CITY OF ALBUQUERQUE

May 12, 2023

Re: Ventura Plaza Self Storage
8041 Ventura St. NE
Traffic Circulation Layout
Engineer's/Architect's Stamp XX-XX-XX (D20-D010D)

Based upon the information provided in your submittal received 04-28-23, the above referenced plan cannot be approved for Building Permit until the following comments are addressed:

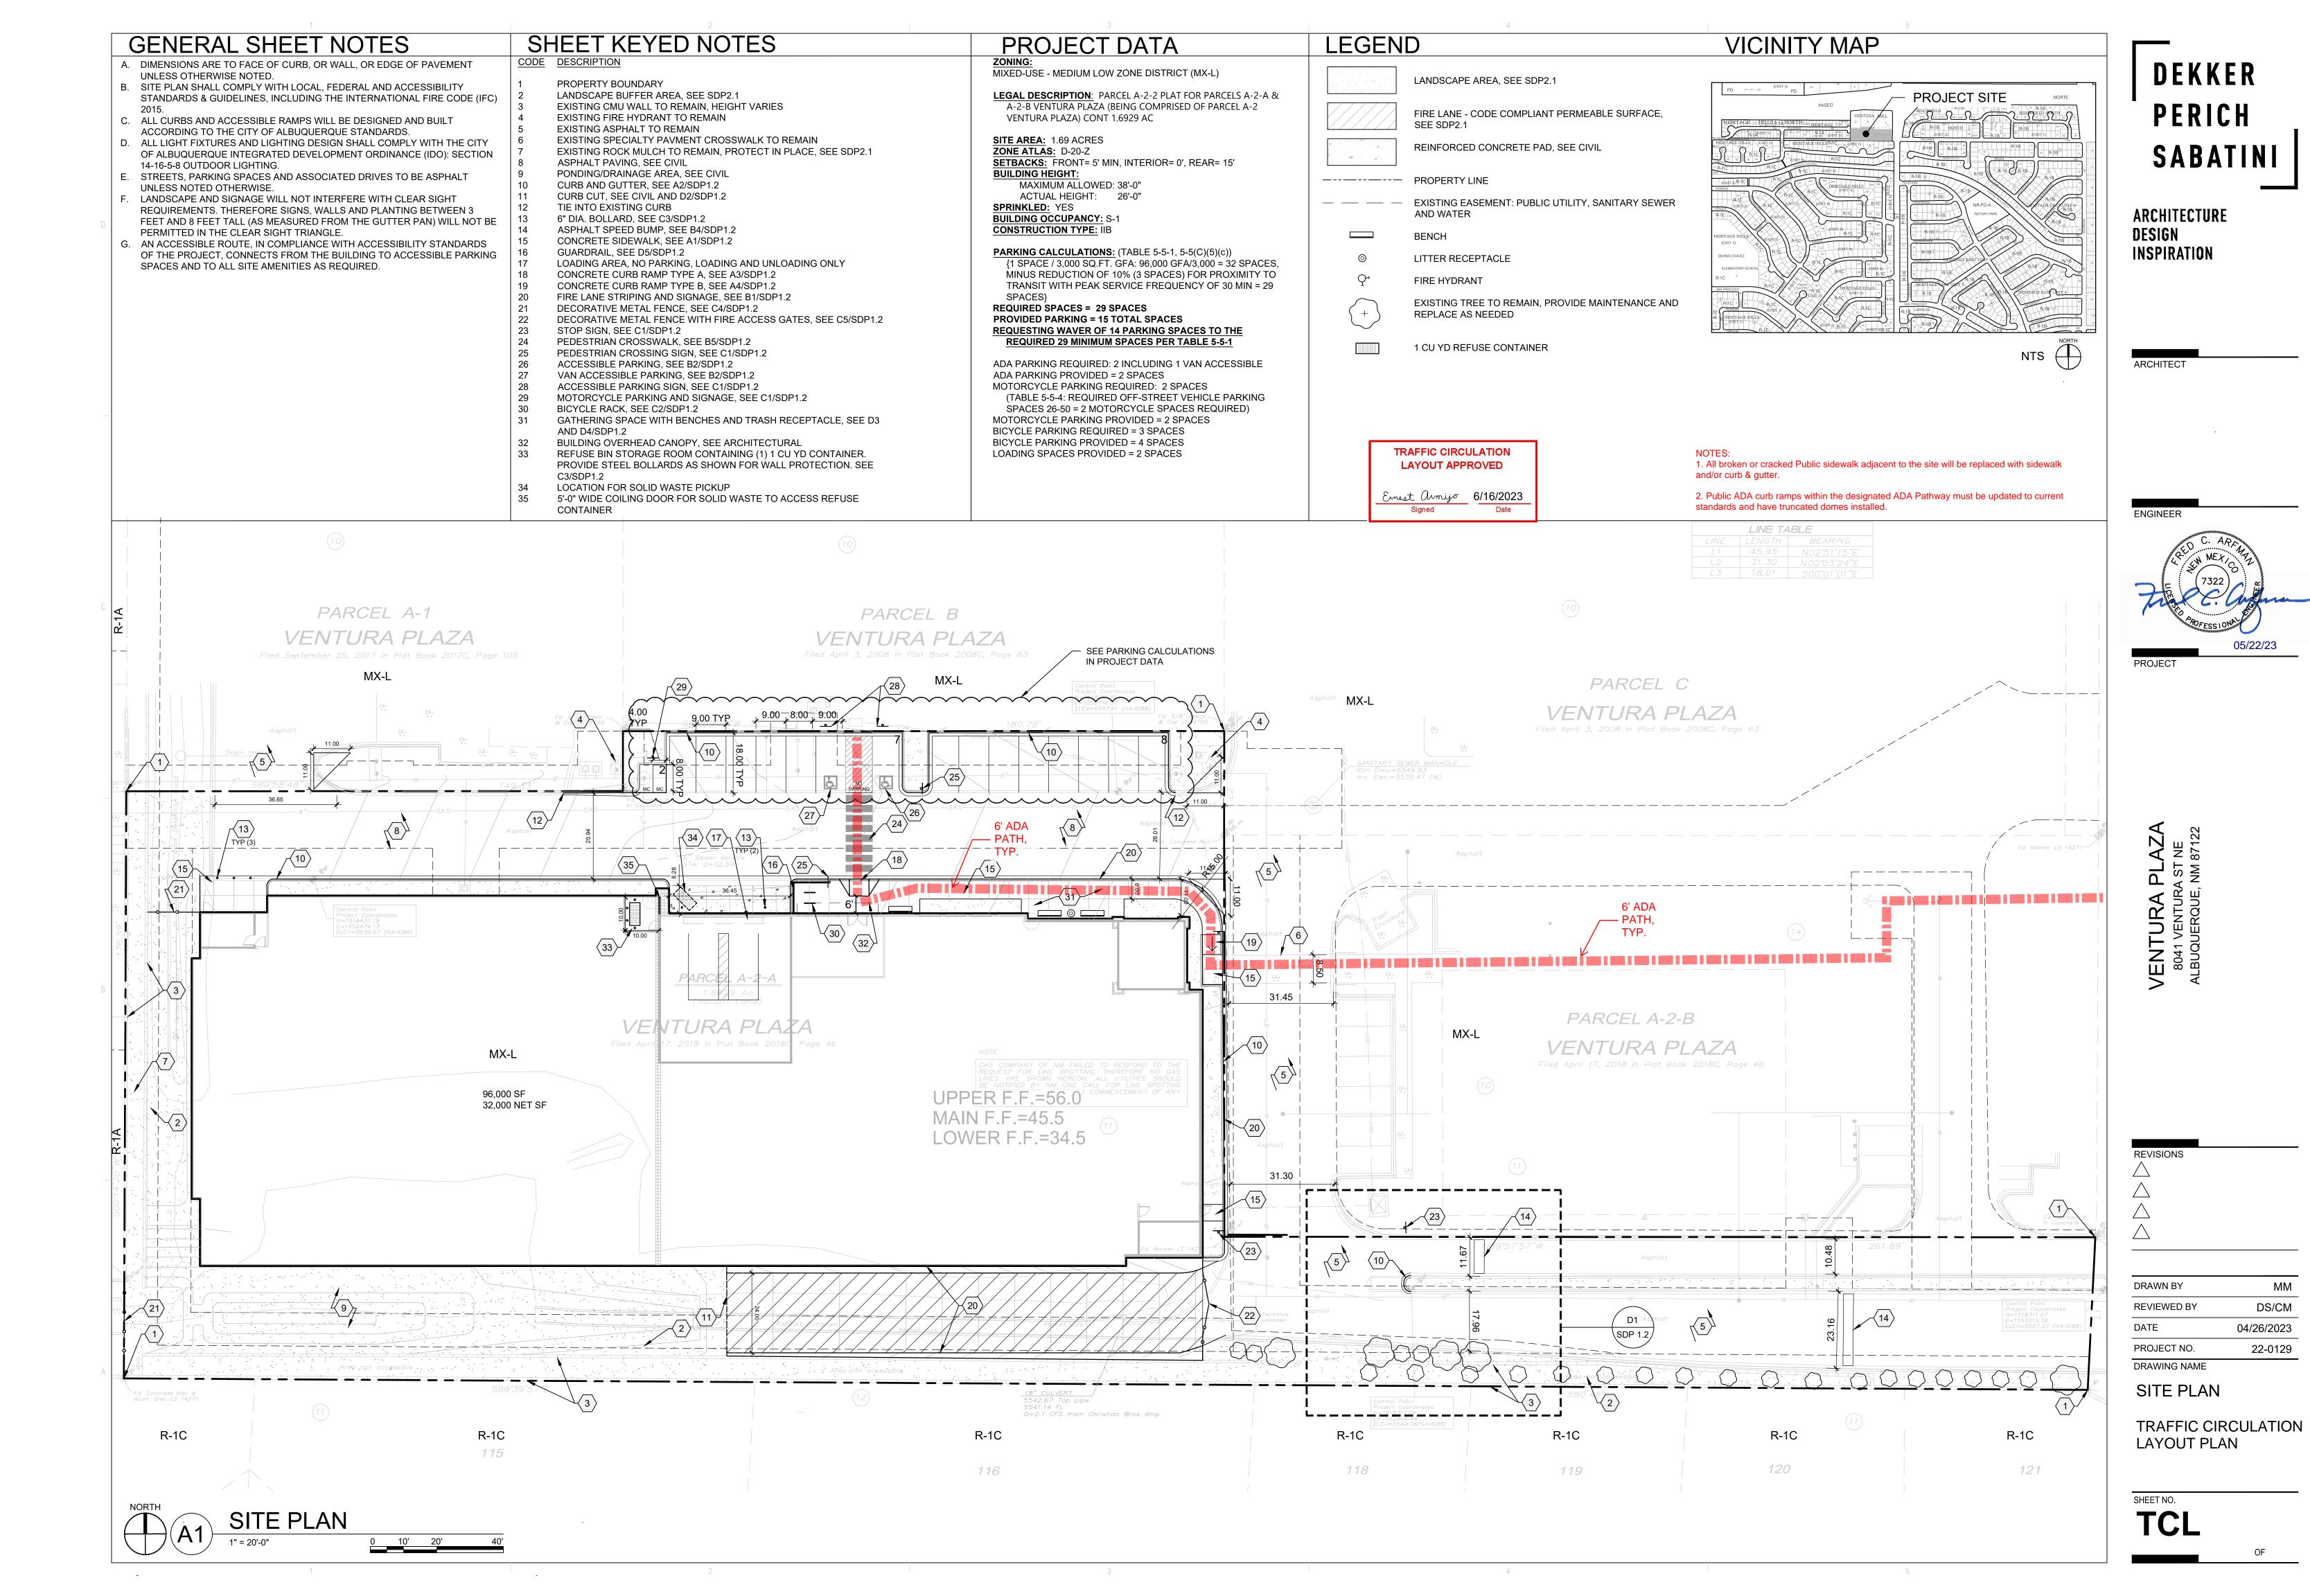
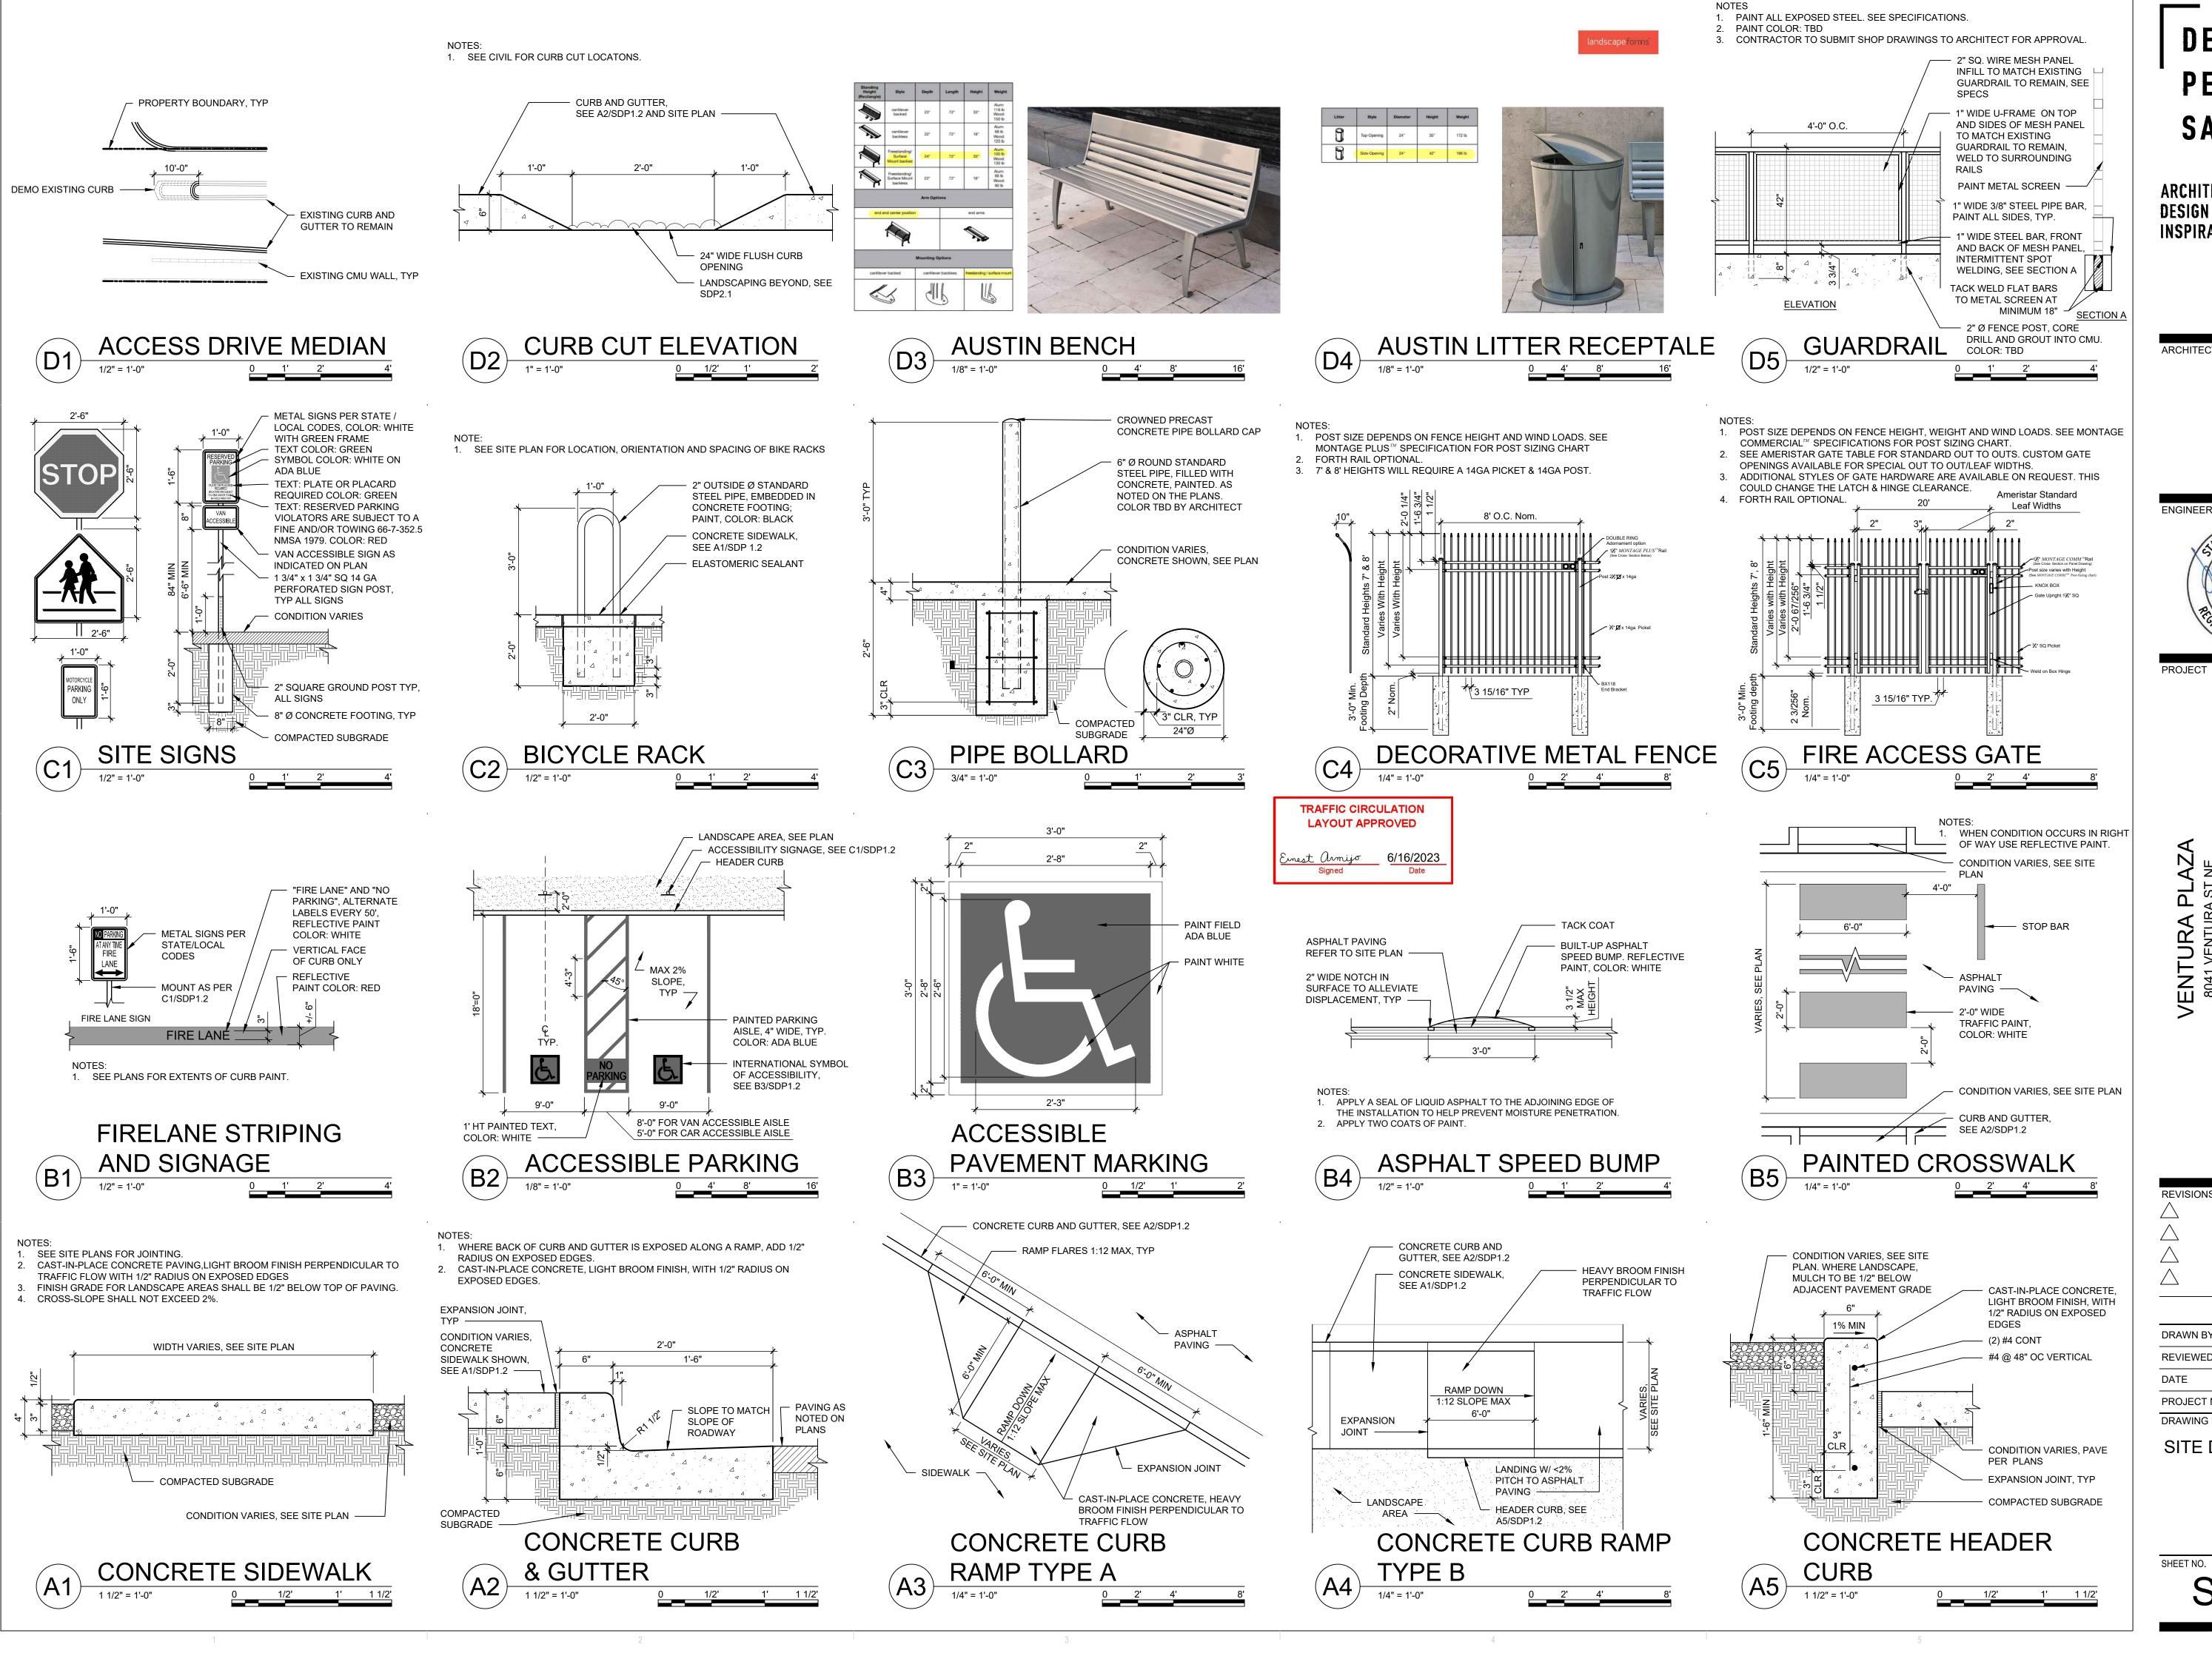
5. Please provide details for all the proposed ADA ramps, and reference COA std dwg.
6. The ADA accessible parking sign must have the required language per 66-7-352.4C NMSA 1978 **"Violators Are Subject to a Fine and/or Towing."** Please call out detail and location of signs. **Will be addressed at Building Permit**

7. The ADA access aisles shall have the words **"NO PARKING"** in capital letters, each of which shall be at least one foot high and at least two inches wide, placed at the rear of the parking space so as to be close to where an adjacent vehicle's rear tire would be placed. (66-1-4.1. B NMSA 1978) **Will be addressed at Building Permit**

8. ADA curb ramps must be updated to current standards and have truncated domes installed. **Will be addressed at Building Permit**
9. Motorcycle parking spaces shall be designated by its own conspicuously posted upright sign, either free-standing or wall mounted per the zoning code. **Will be addressed at Building Permit**

10. The pavement marking "MC" should be shown in the opposite direction for motorcycles entering the parking space. **Will be addressed at Building Permit**

- 14. Bicycle parking spaces shall be at least 6 feet long and 2 feet wide. Will be addressed at Building Permit
 - 15. Per the IDO, a 6 ft. wide ADA accessible pedestrian pathway is required from the public sidewalk to the building entrances. Please clearly show this pathway and provide details. Path Addressed, Details will be addressed at Building Permit

- 16. Per DPM, a 6 ft. wide ADA accessible pedestrian pathway is required from the ADA parking stall access aisles to the building entrances. Please clearly show this pathway and provide details. Please show this dimension on the site plan. Path Addressed, Details will be addressed at Building Permit
